Re: Baze-Inoguchi Residence  
Building Permit #2006-188

The following is in response to the Intake Comments CST dated July 21, 2020 for your review.

Re: Baze-Inoguchi

I have reviewed the building department intake comments and made the following revisions in response to these comments.

NW 1/4 OF NW 1/4 SEC 12, TWP. 24N., RGE 04E., W.M.

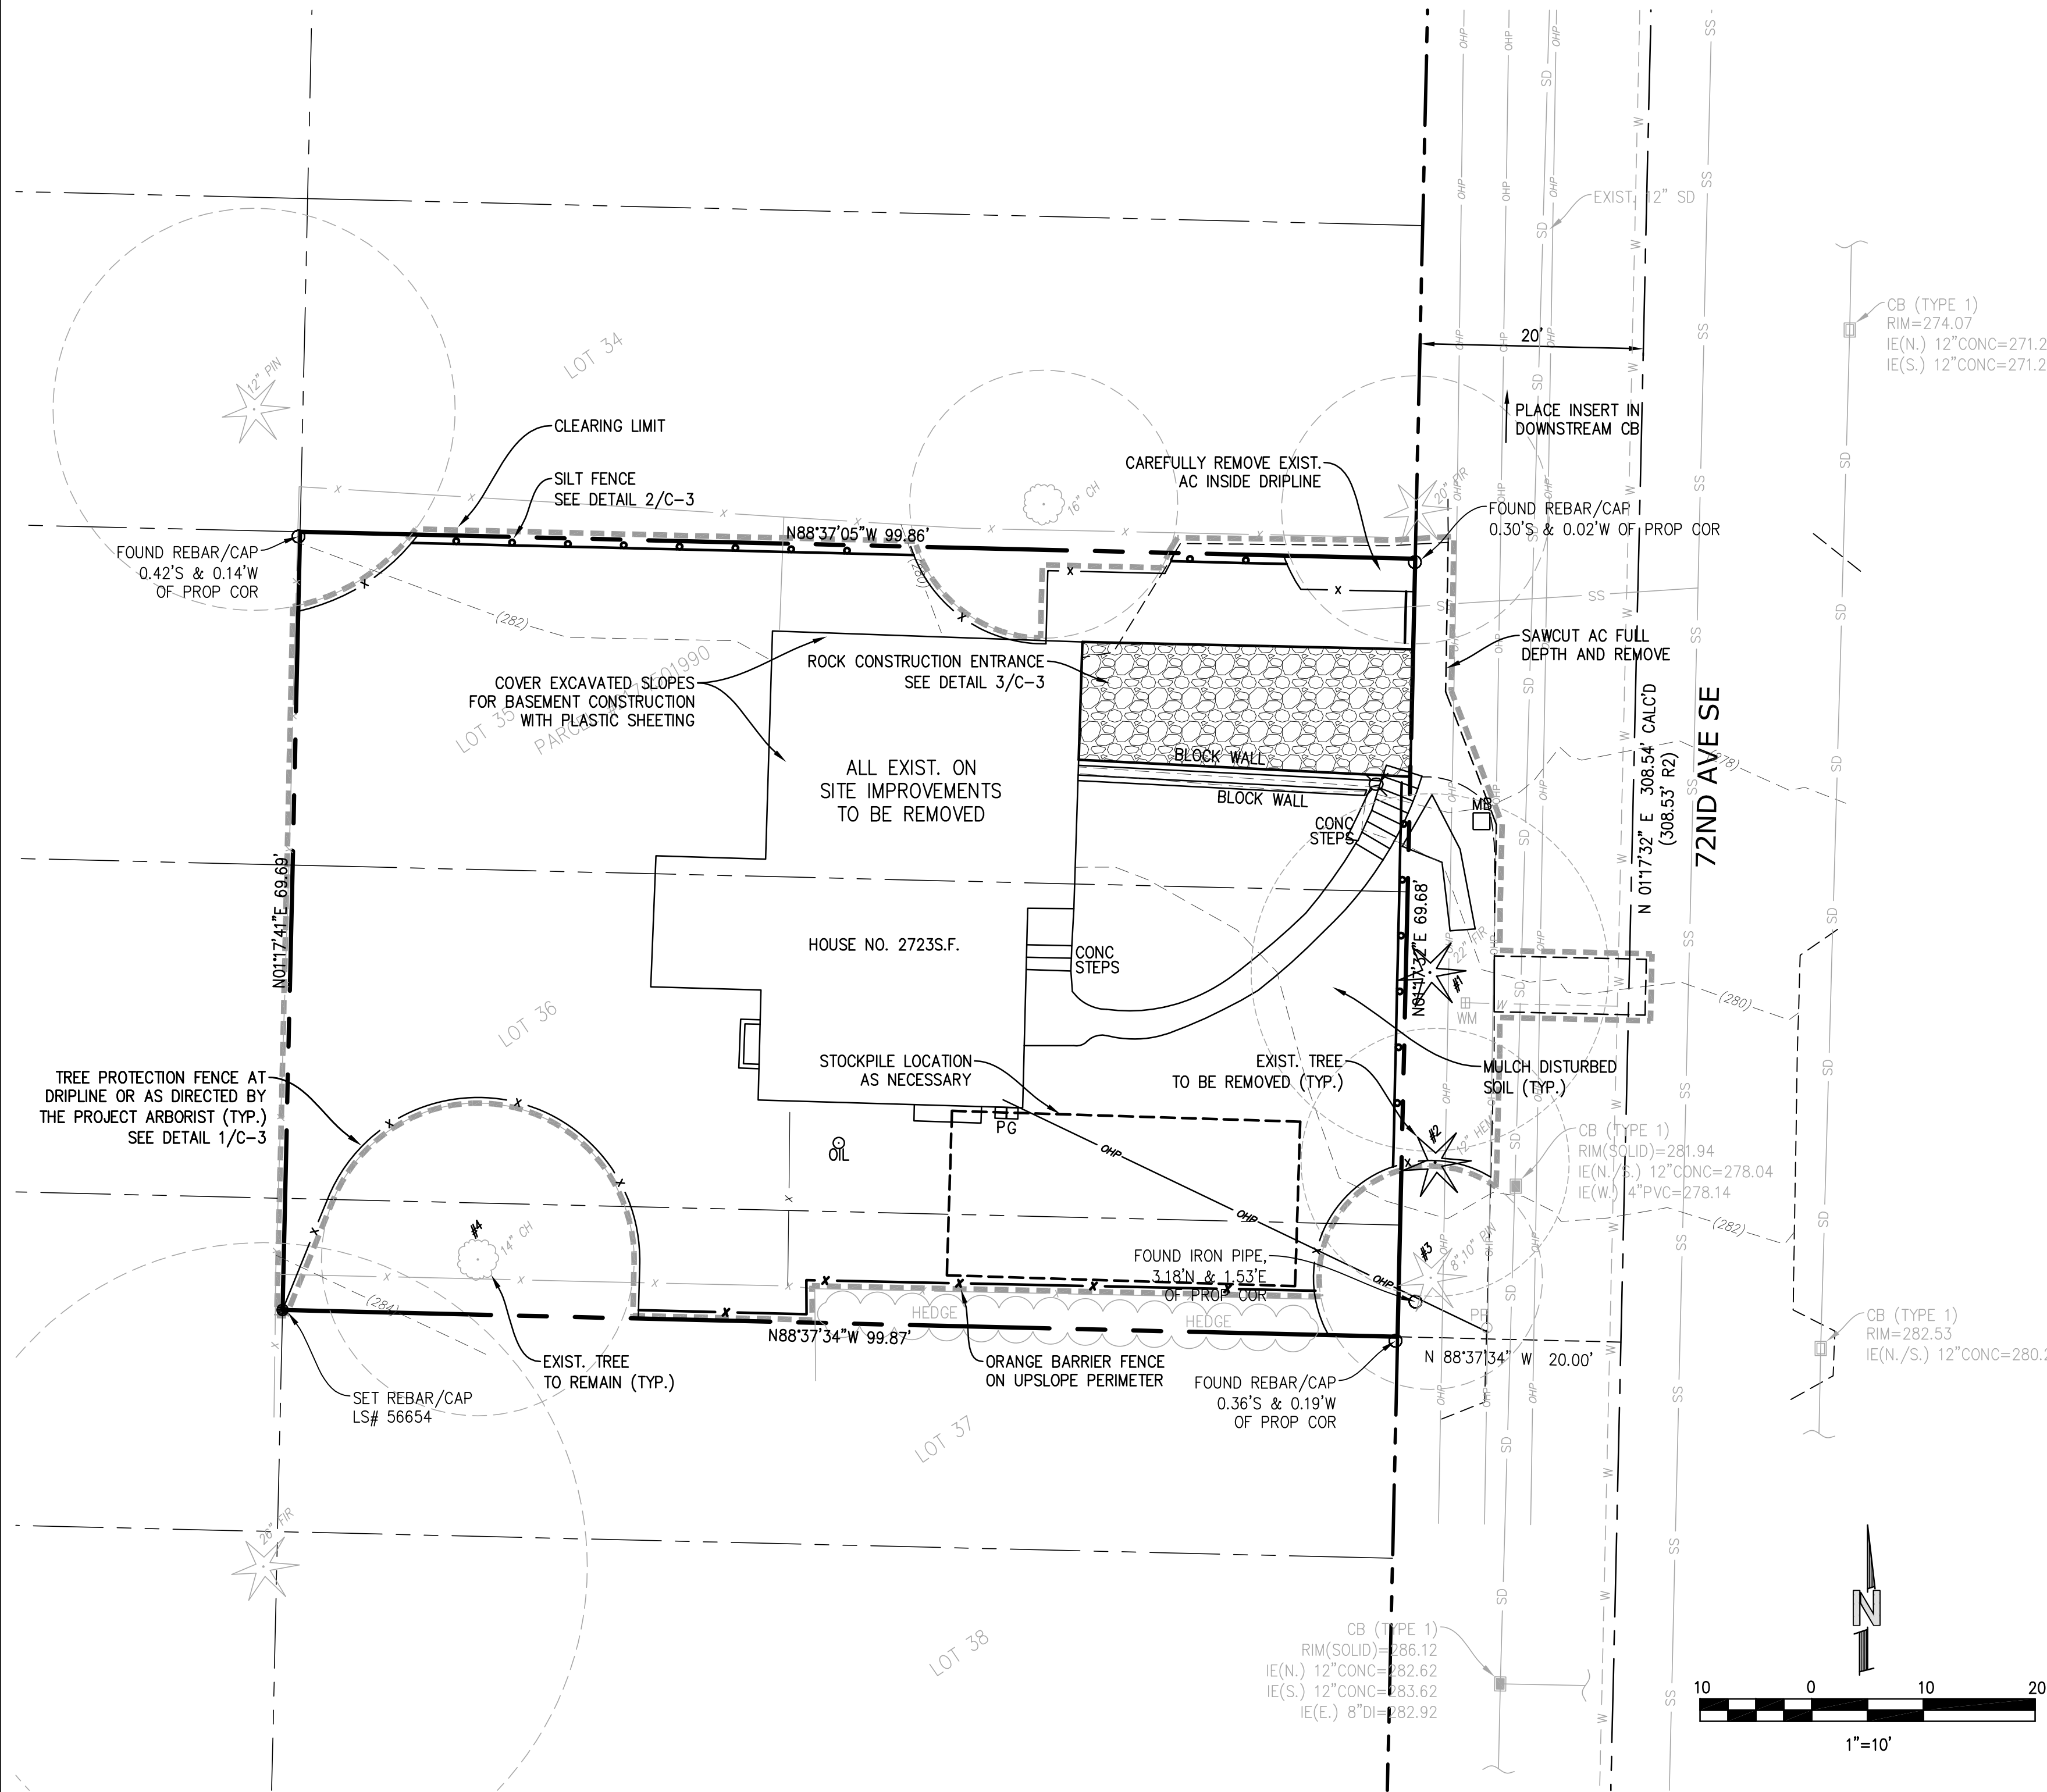
1. Provided legal description.
2. Added driveway length & width.
3. Added building pad area. Sheet A0.2.
4. Added amount of covered & uncovered parking stalls.

1 FRONT ELEVATION (EAST)

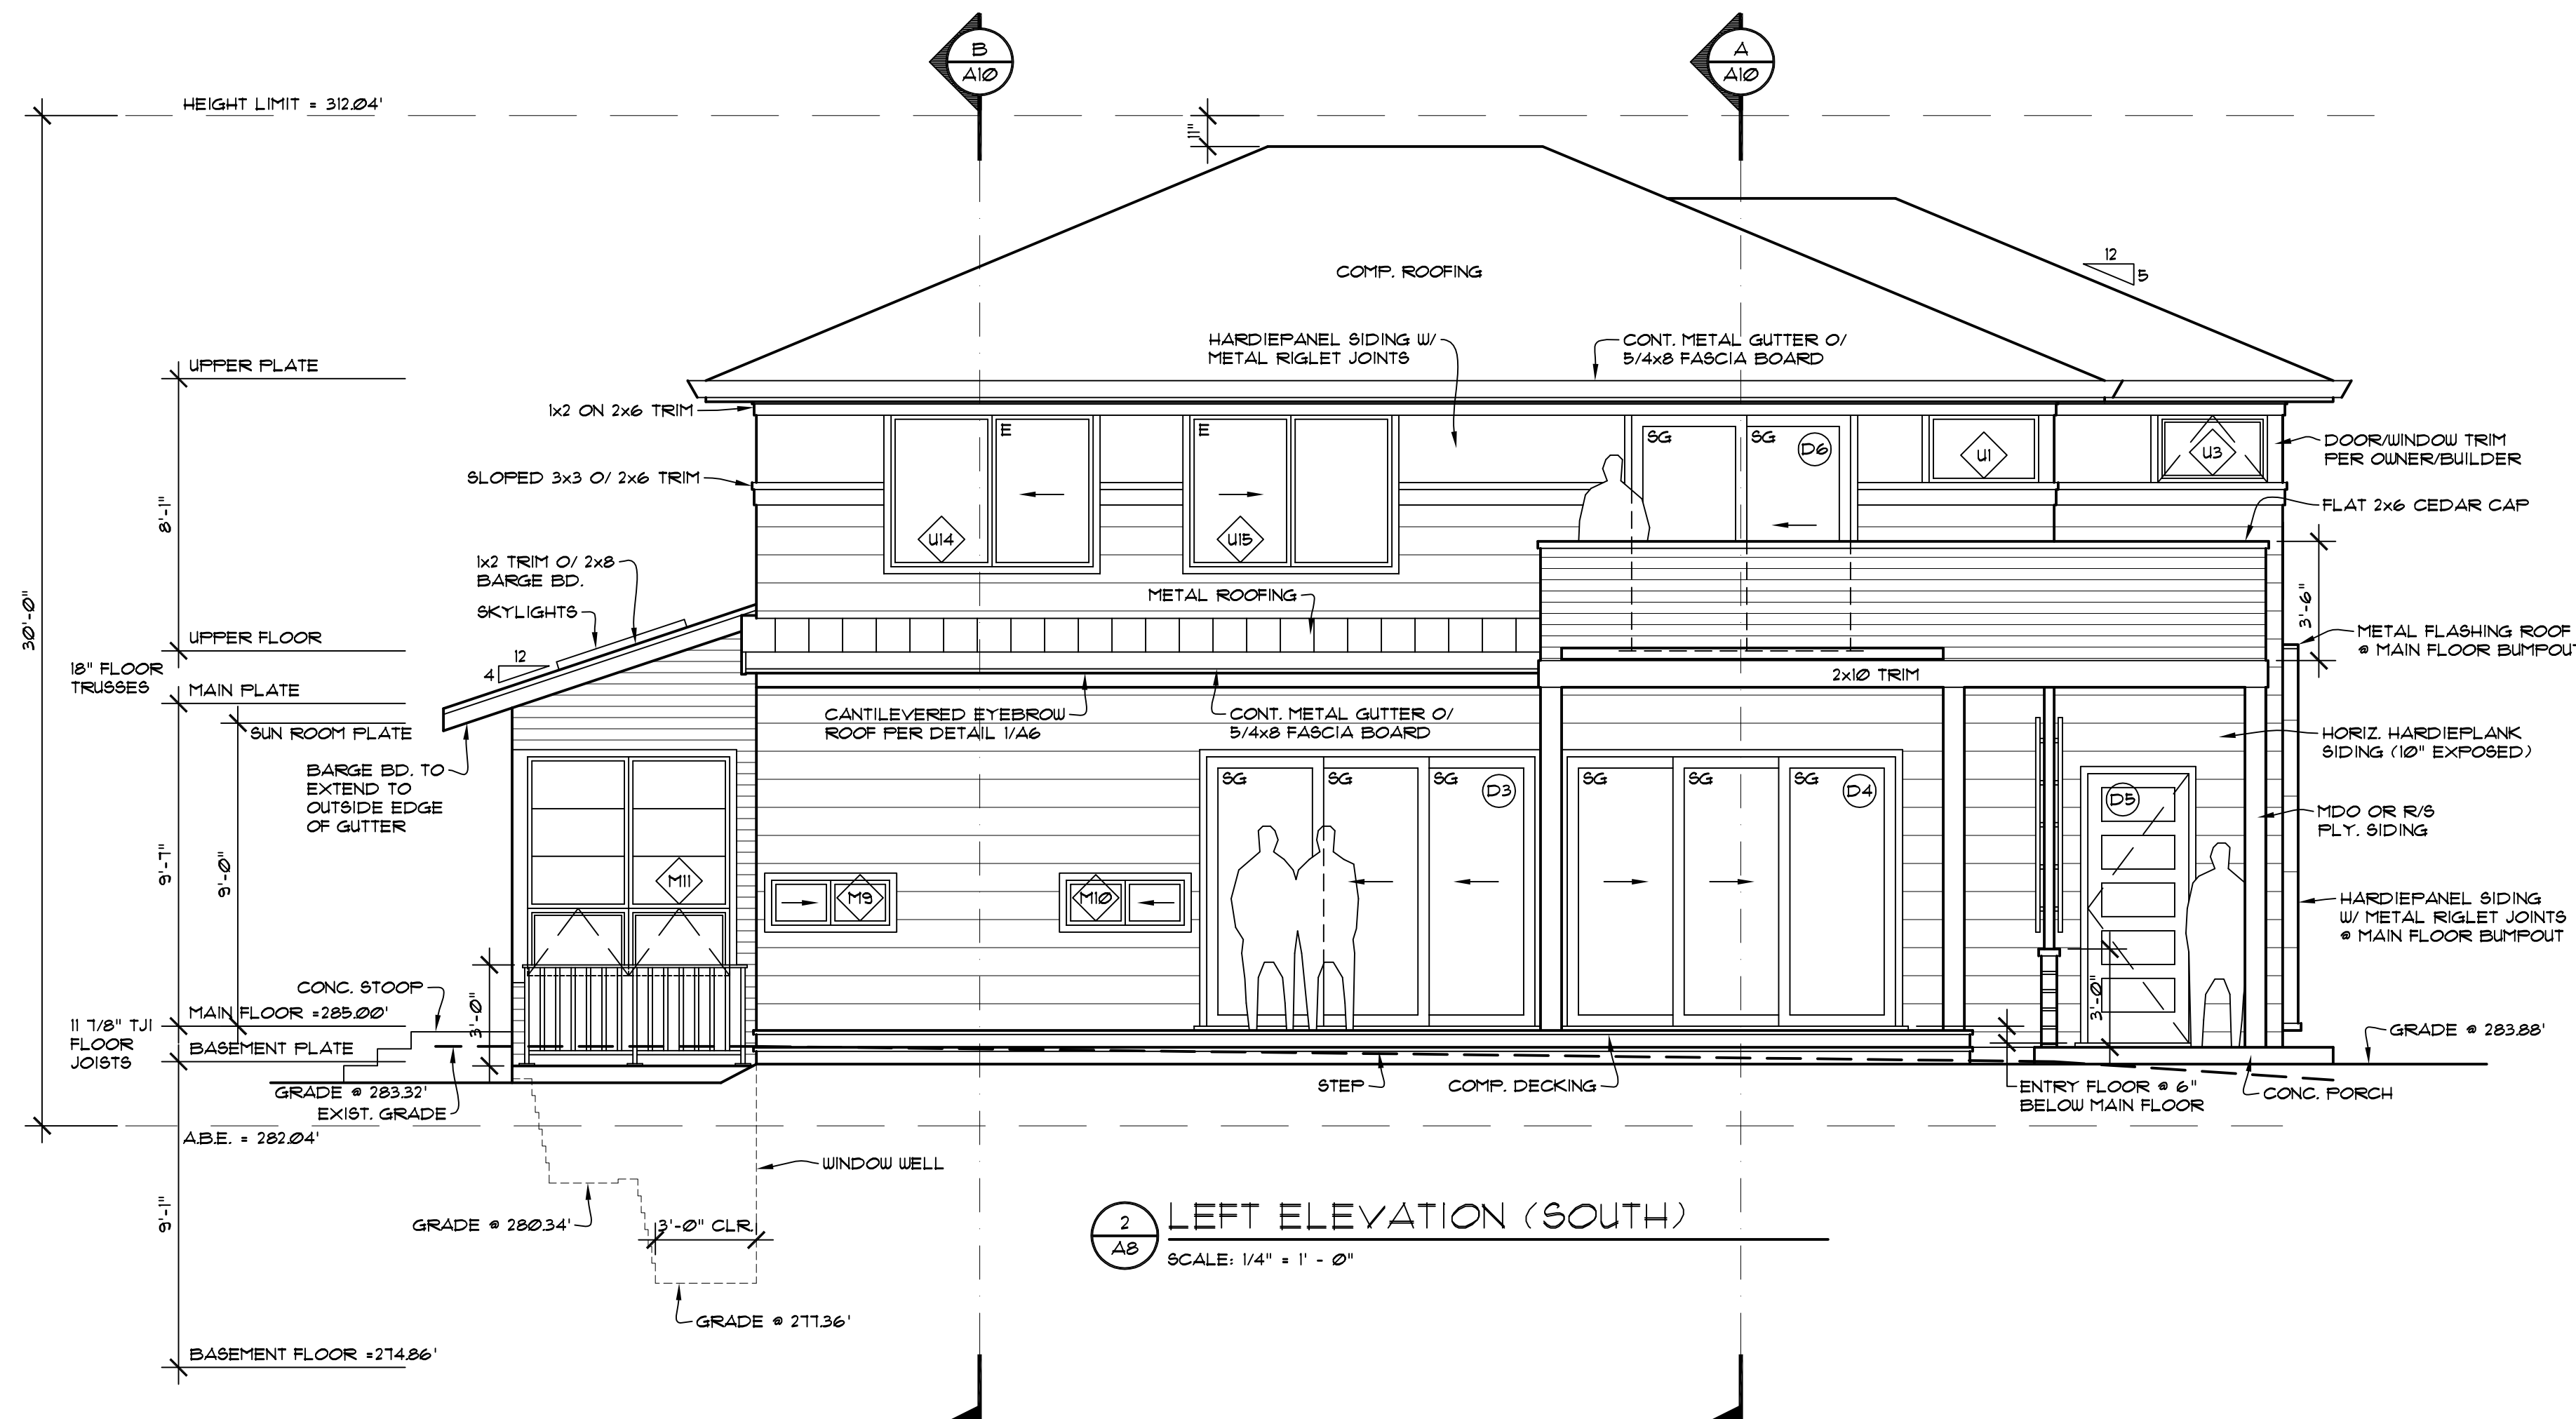
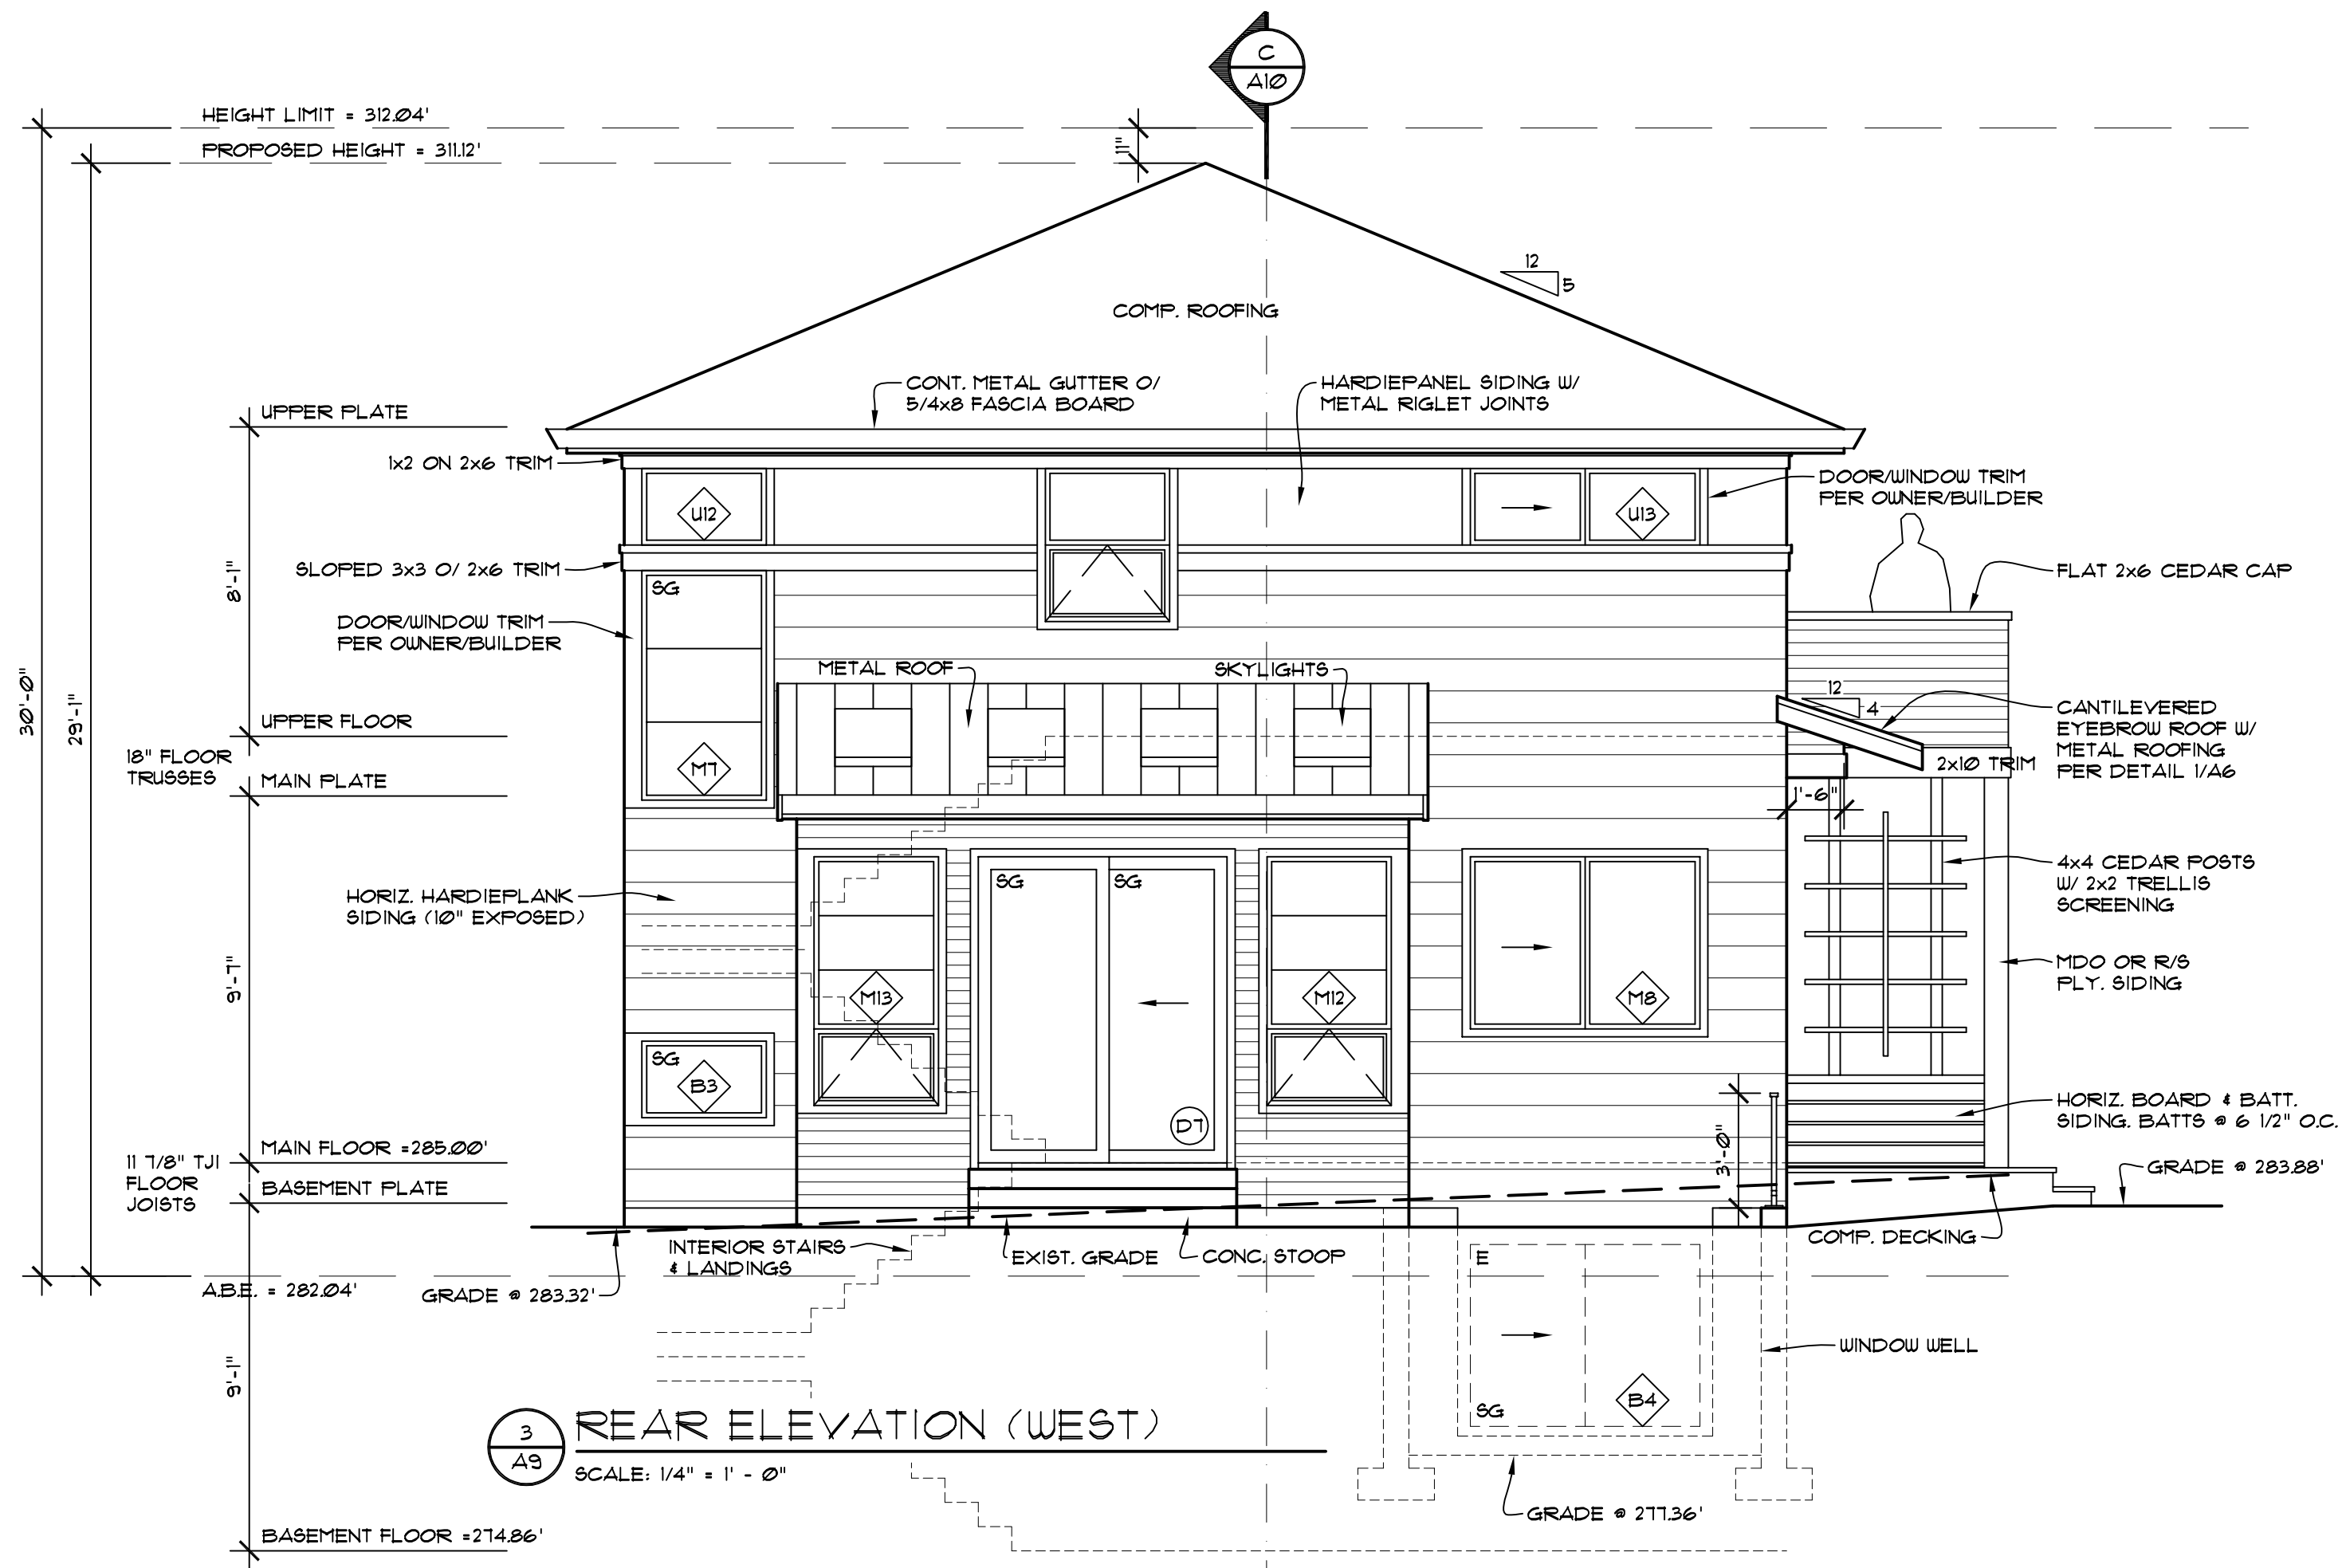
1. Added building height note.
2. Added existing grade lines.
3. Added downhill building façade height dimension.
4. Added grading cut & amount outside footprint to site plan.
